National Infrastructure Planning  
Temple Quay House  
2 The Square  
Bristol, BS1 6PN

Our Ref: EN010127

### **Application by Mallard Pass Solar Farm Limited for an Order Granting Development Consent for the Mallard Pass Solar Project**

#### **Advice following issue of decision to accept the application for examination**

Traffic Regulation Measures Plans - Temporary Measures

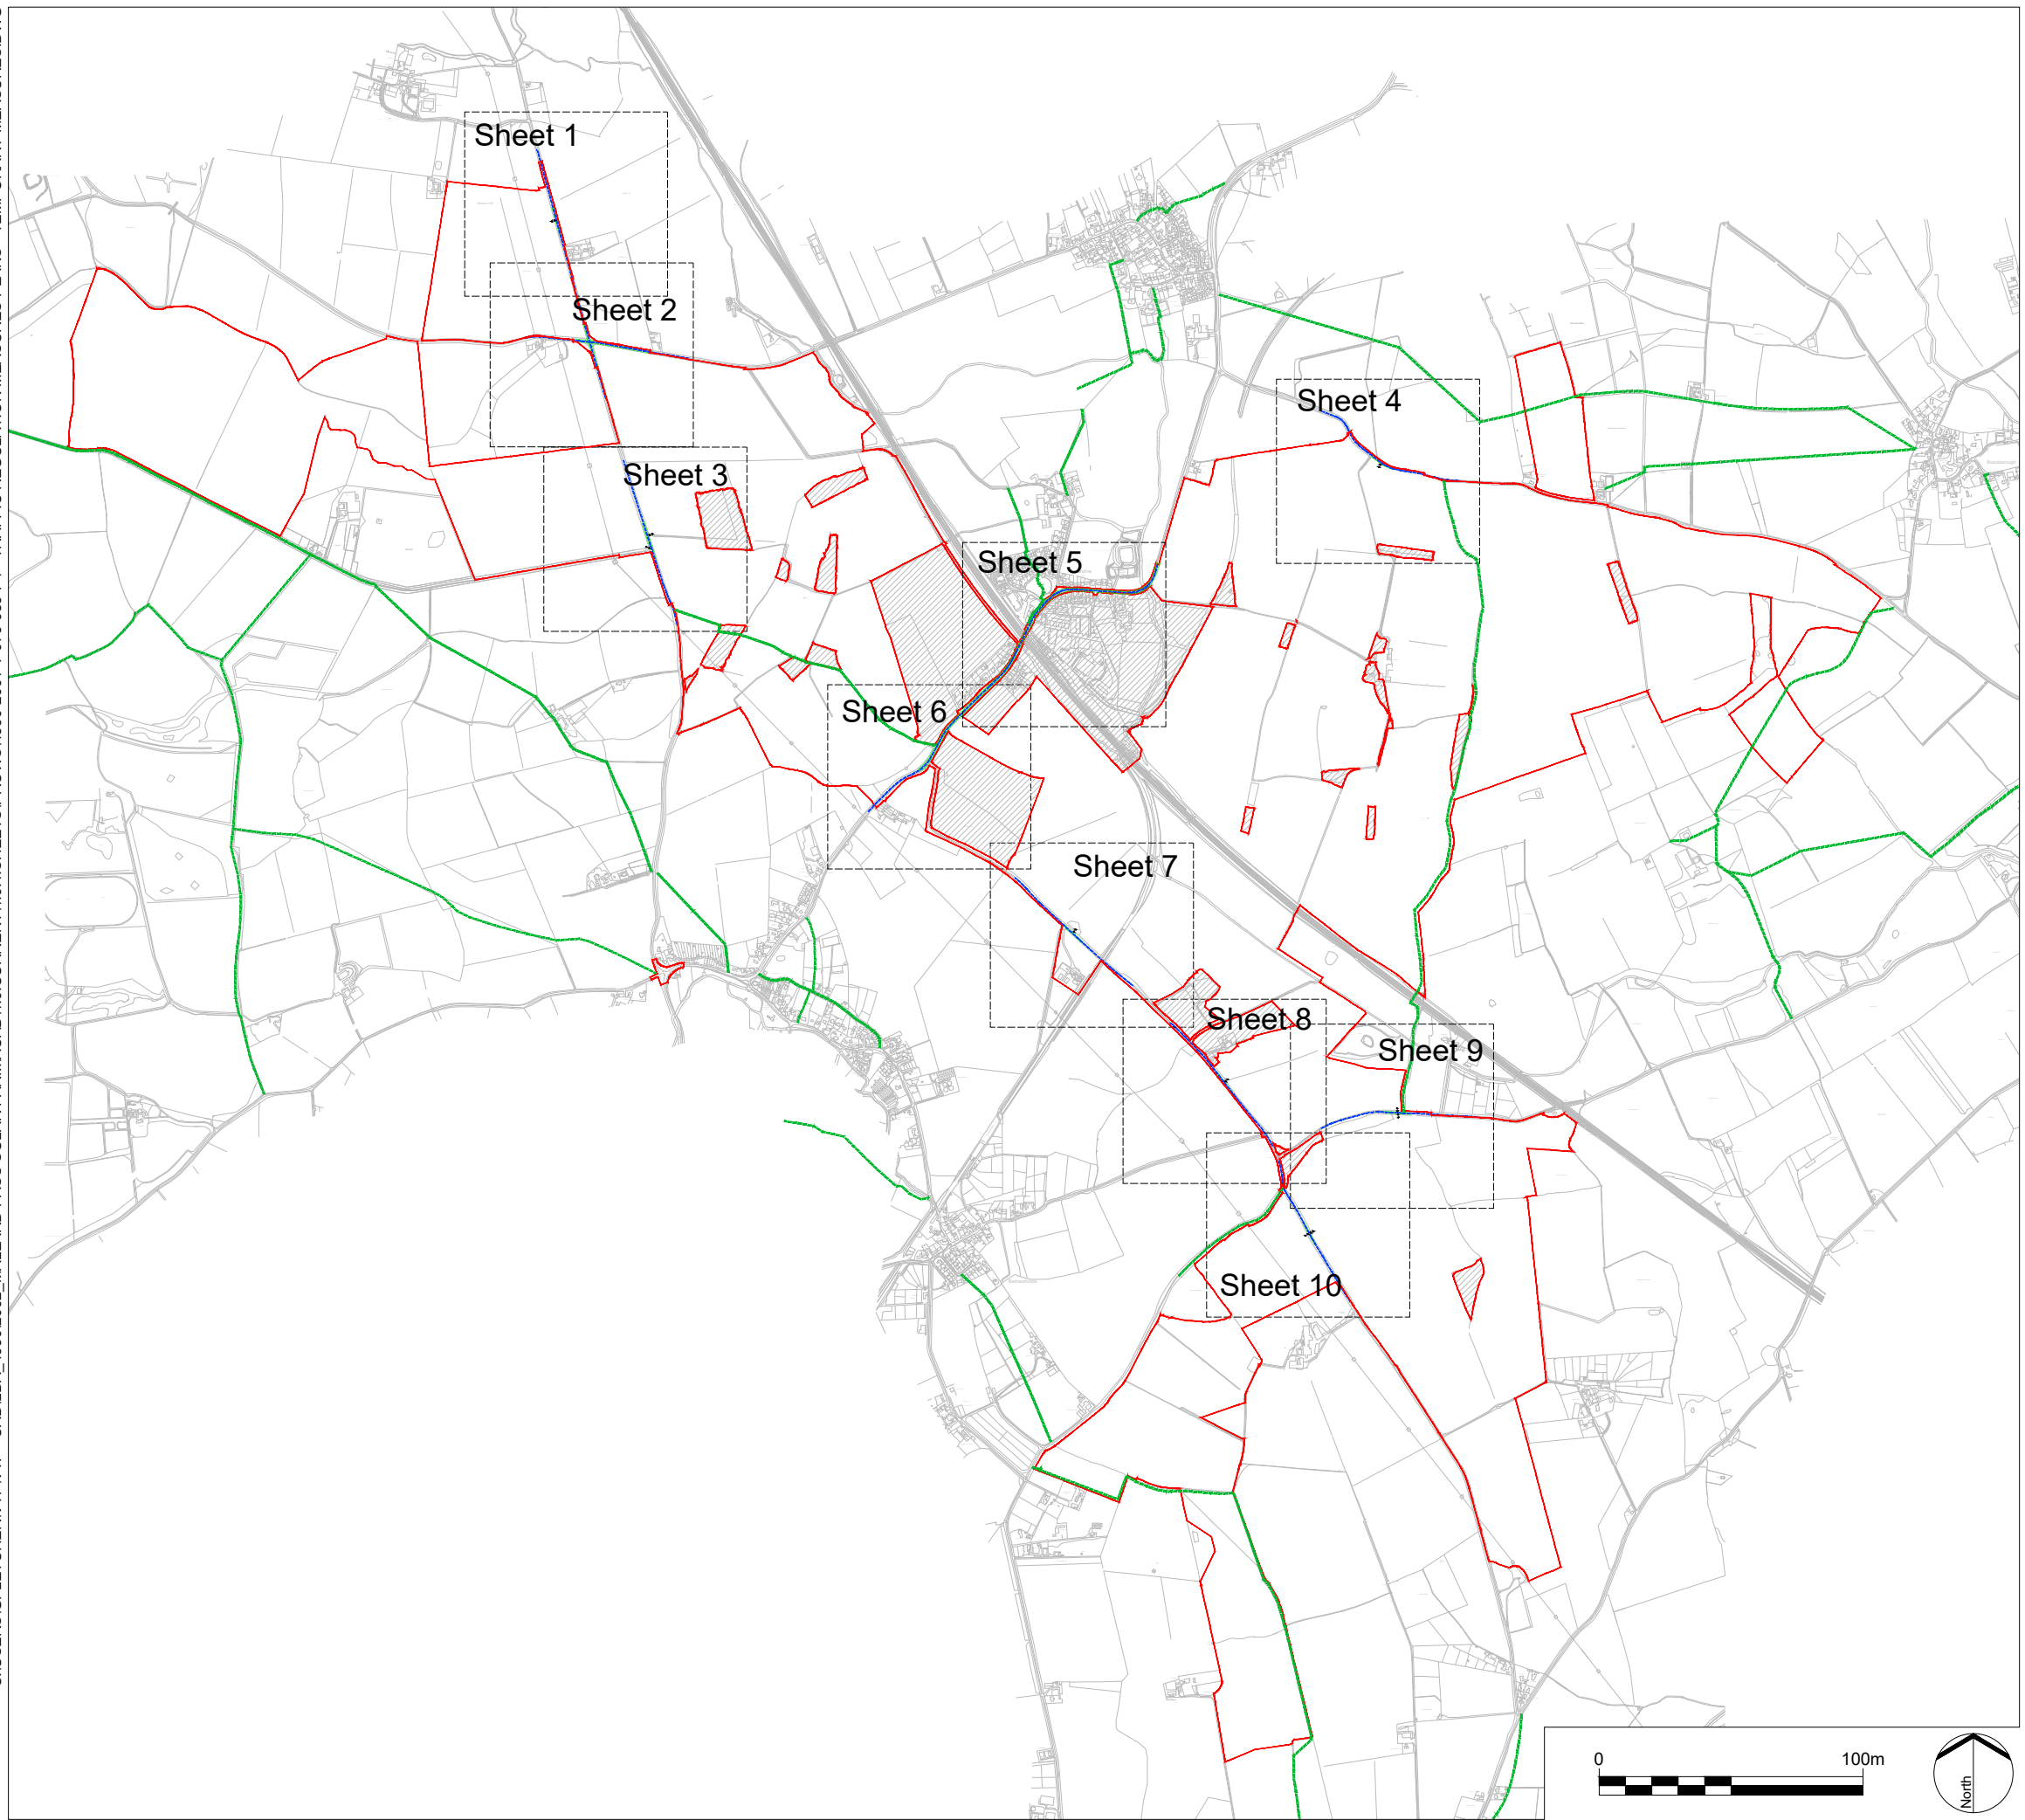
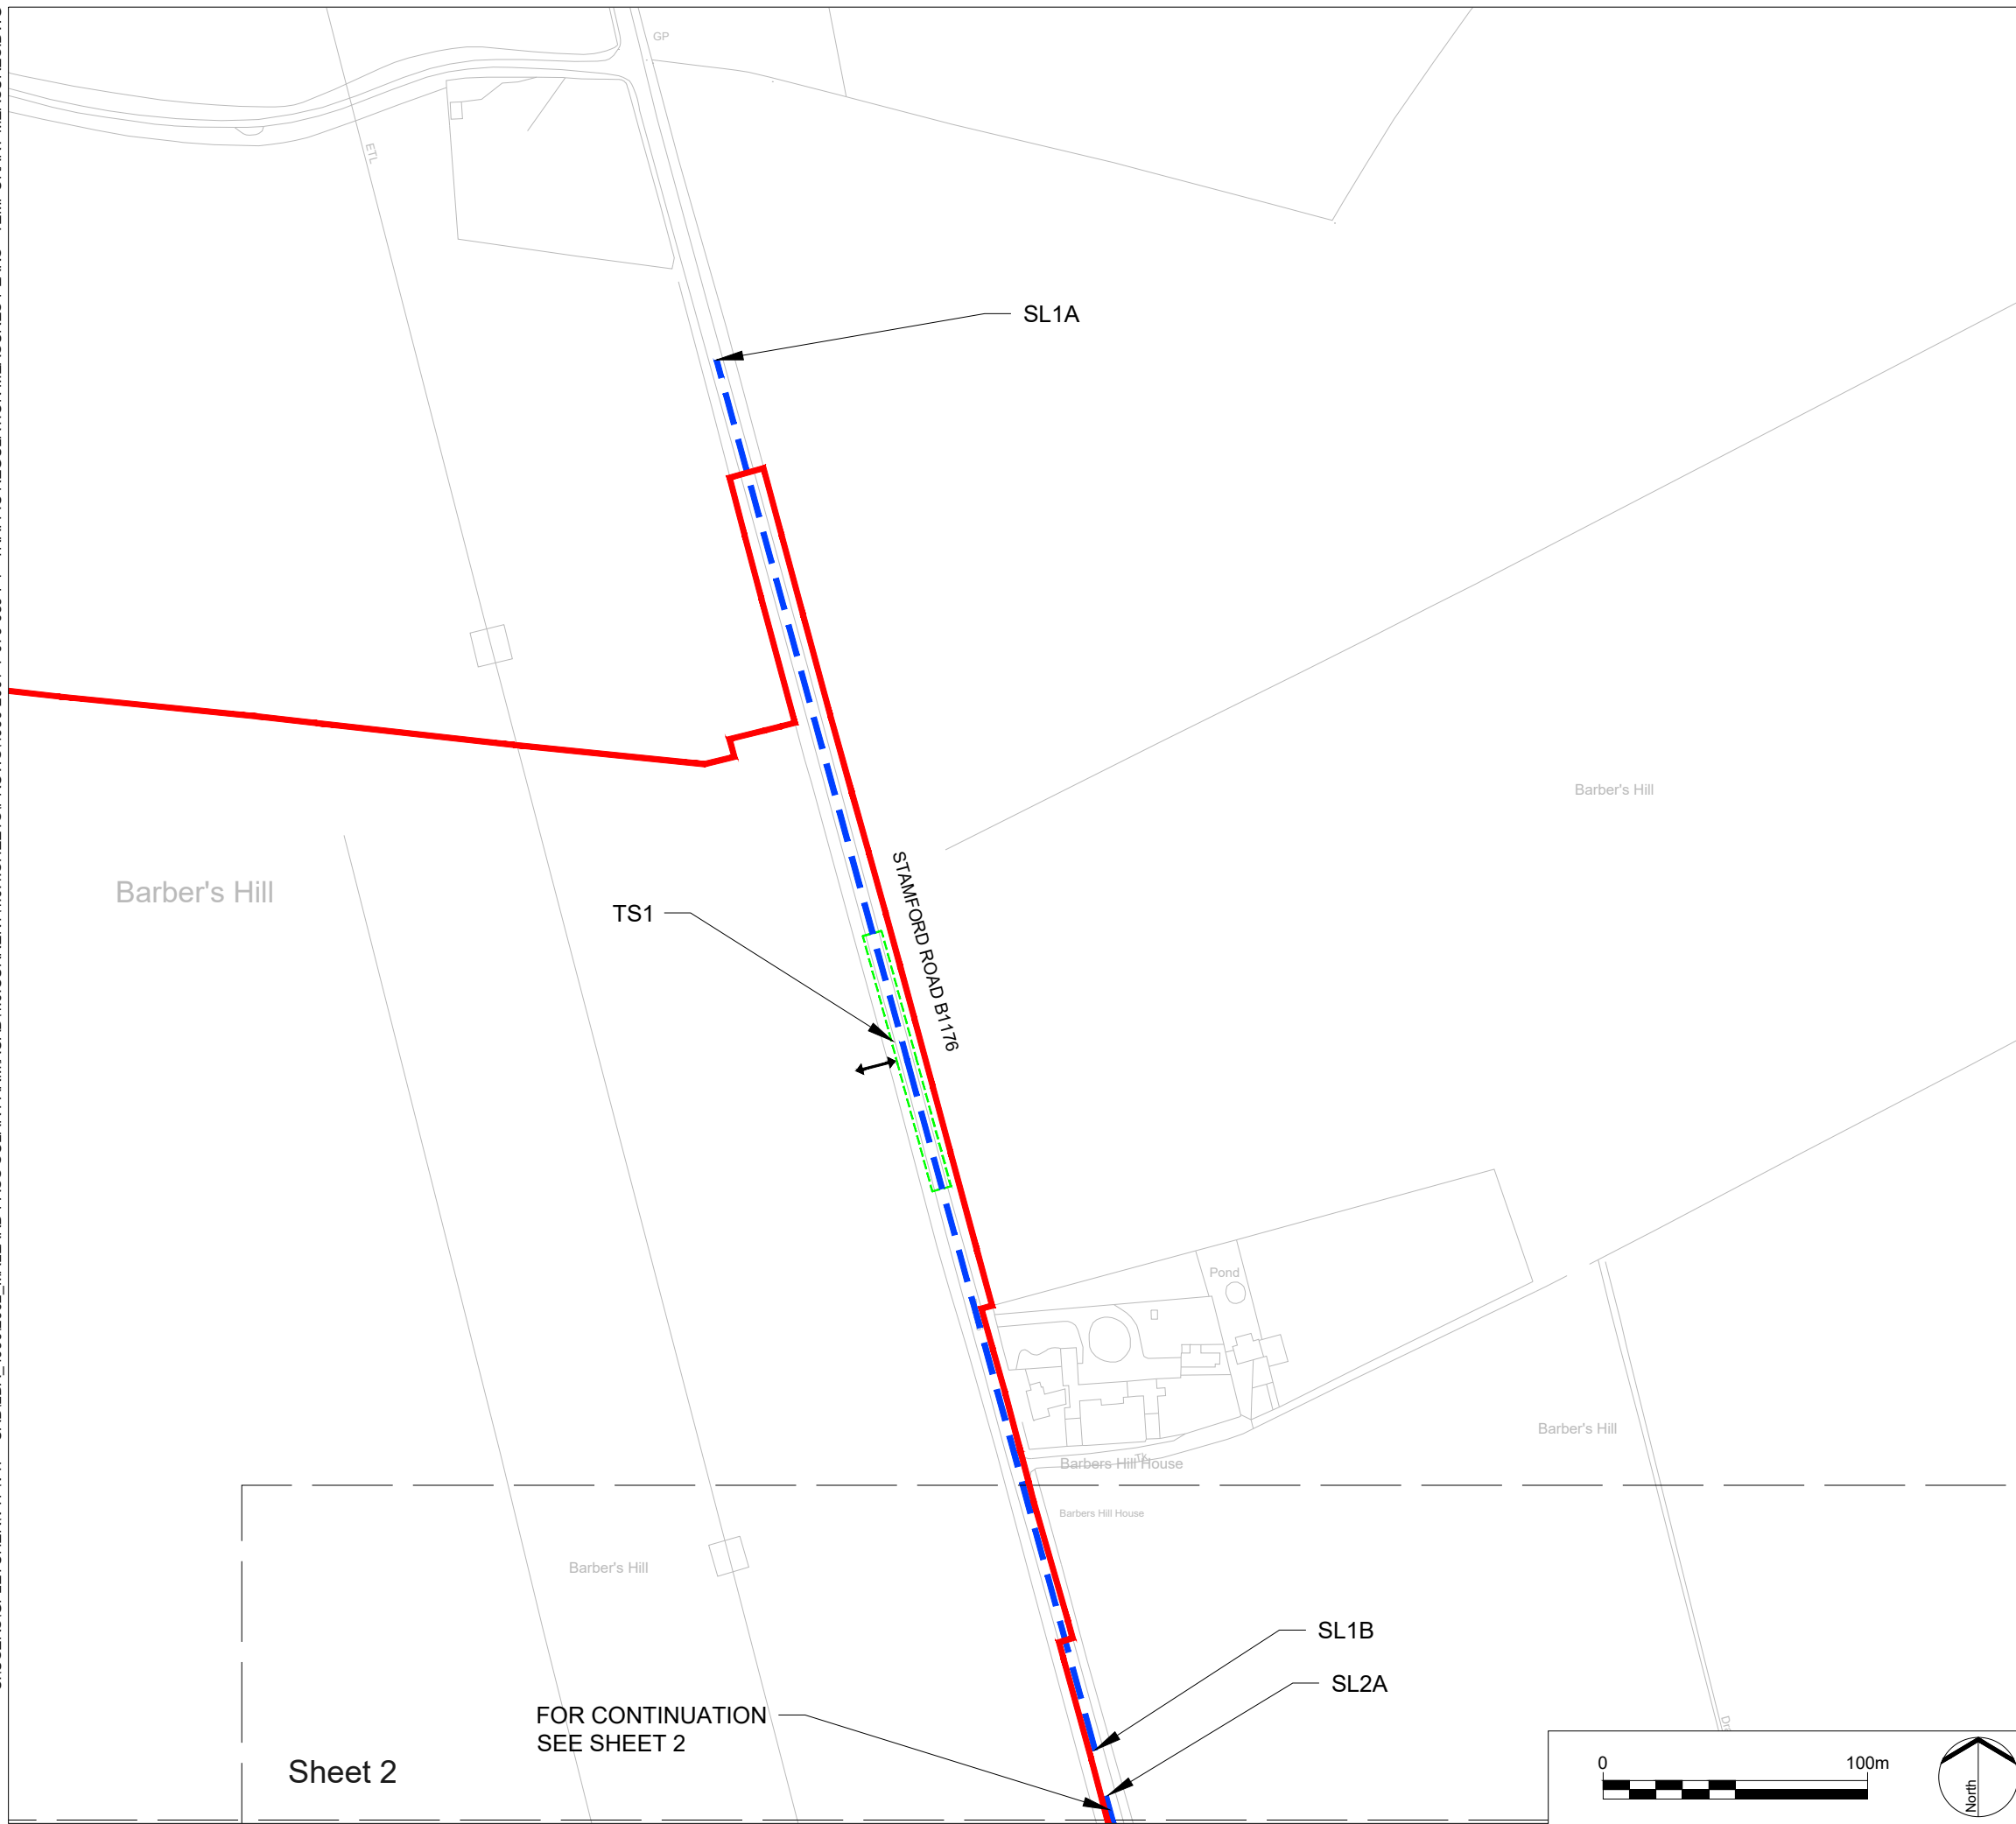
For clarity and to help understanding, existing public footpaths (public rights of way) should be marked and the plans more clearly notated to reflect the proposals, including differentiating works to footpaths and roads.
